From: [Torrey, Elizabeth M \(DFW\)](#)
To: [Rachael Stevie \(CD\)](#)
Cc: [Vicki](#)
Subject: RE: SE-21-00009 Hobbs - Notice of Application
Date: Tuesday, May 4, 2021 12:24:17 PM
Attachments: [image001.png](#)

I am the biologist with WDFW working with Ms. Hobbs on this project. I do not have a comment, per say, on the SEPA notice, except for an inaccuracy that I would like to correct for the record:

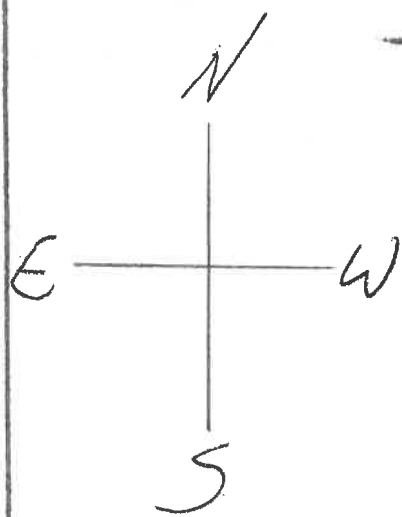
I see in the SEPA NOA that the waterbody is listed at being Type 9, and 2' wide. **During my 3/25/21 site visit I concluded that this waterbody, a fish-bearing tributary to Schnebly Creek, warrants Type 3 classification. I measured the bankfull width at 15'.**
